Martin Nugent  
01254 828060  
D3/12/0002

**Planning Applications, Ribble Valley District  
3/12/0002 Pepper Hill, Wiswell**

Existing Site Plan 1:500

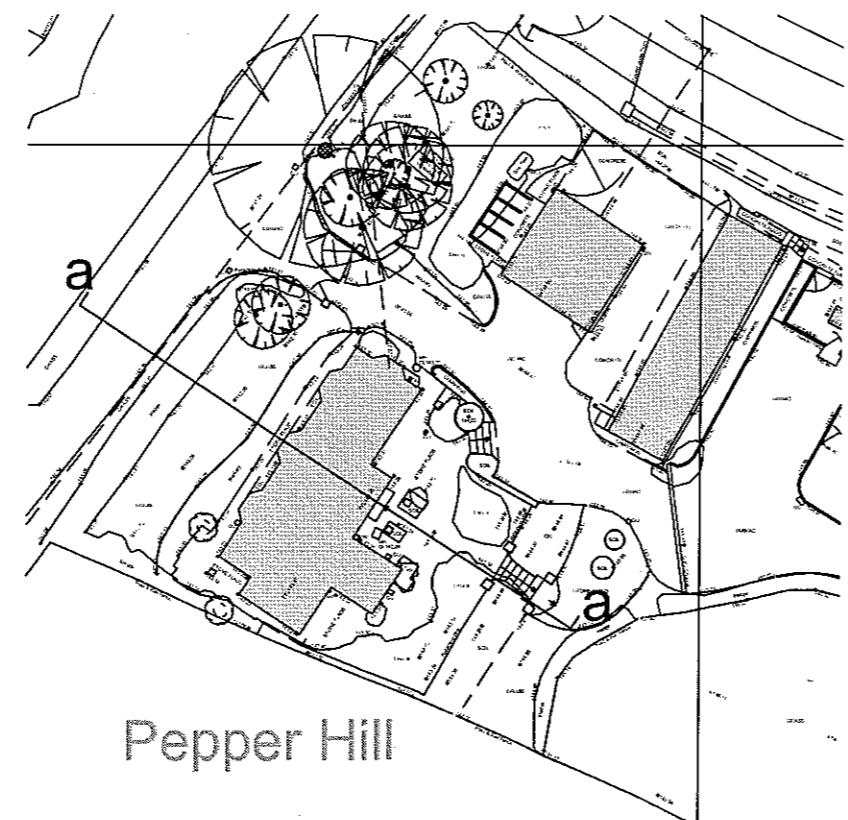
The plans provided do not give a clear indication of the sightlines that can be achieved from the site onto Pendleton Road. However, it is apparent from visiting the site that the minimum sightlines (2.4m by 40m) required for a property of this type exiting onto a road of this width, are achieved.

I would ask that a condition be applied that all future planting or construction that falls within the 2.4m by 40m visibility splay is maintained at a height below 1.0m.
